DATE: 27 November 2023

LPA Refs: RB2021/1089

Reference: 2021/1089

Location: *Land to the South East of Higham Common Road, Barnsley (Employment).*

Figure 3 – Illustrative Masterplan

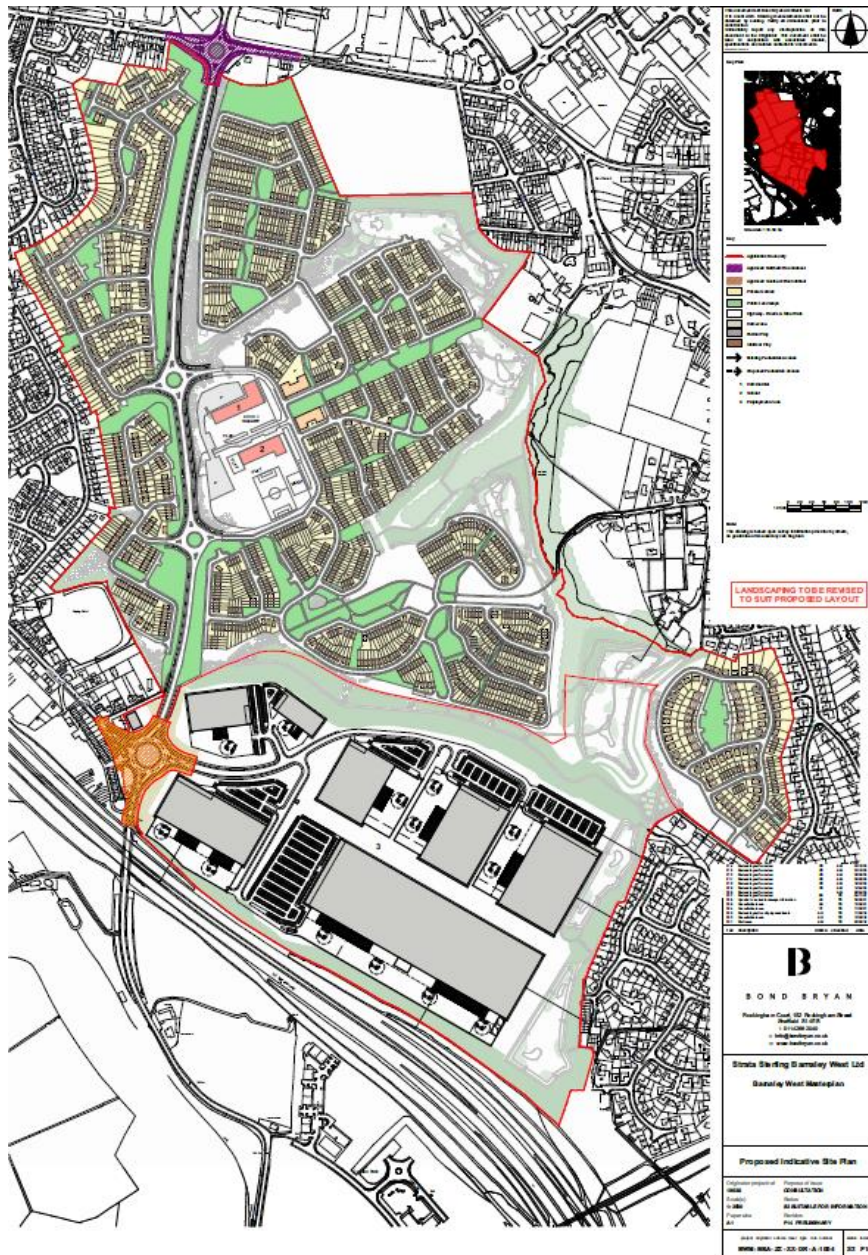
It will be necessary to install bus stops and appropriate bus stop infrastructure along the agreed route of the bus service(s) to support both the proposed residential and employment uses. The current layout is shown on the *Proposed Indicative Site Plan*, drawing no. BWM BBA ZZ XX DR A 1004 rev. P16, dated September 2023. With reference to the current layout we have the following comments to make.

**Preferred route:** Our preference is for a direct service along the link road that does not utilise the loop road which comprises part of the residential application.

**Bus laybys:** If the link road is to be designated for a speed limit faster than 30mph then laybys should be provided for the bus stops. We ask that bus stop locations and laybys, if required, are shown on a plan that can be conditioned in the event of the grant of planning permission; this will help to ensure that road and/or pavement works are constructed as part of the link road works.

**Bus stop requirements:** There is a need for 1 pair of bus stops (2 total) to adequately service the proposed employment use. This is in addition to the stops that are required for the residential use

detailed in our response to application 2021/1090. These stops should be located on the link road at indicative locations shown at Annex 1.

**Pedestrian access to bus stops:** Each bus stop should be well related to a safe pedestrian crossing of the link road, and clearly marked access between the stops and the residential/employment areas should be follow desire lines where possible.

**Bus gate/restrictions:** We would ask for confirmation as to the intention to install a bus gate or any carriage restrictions on the link road in order to manage its use as a cut-through.
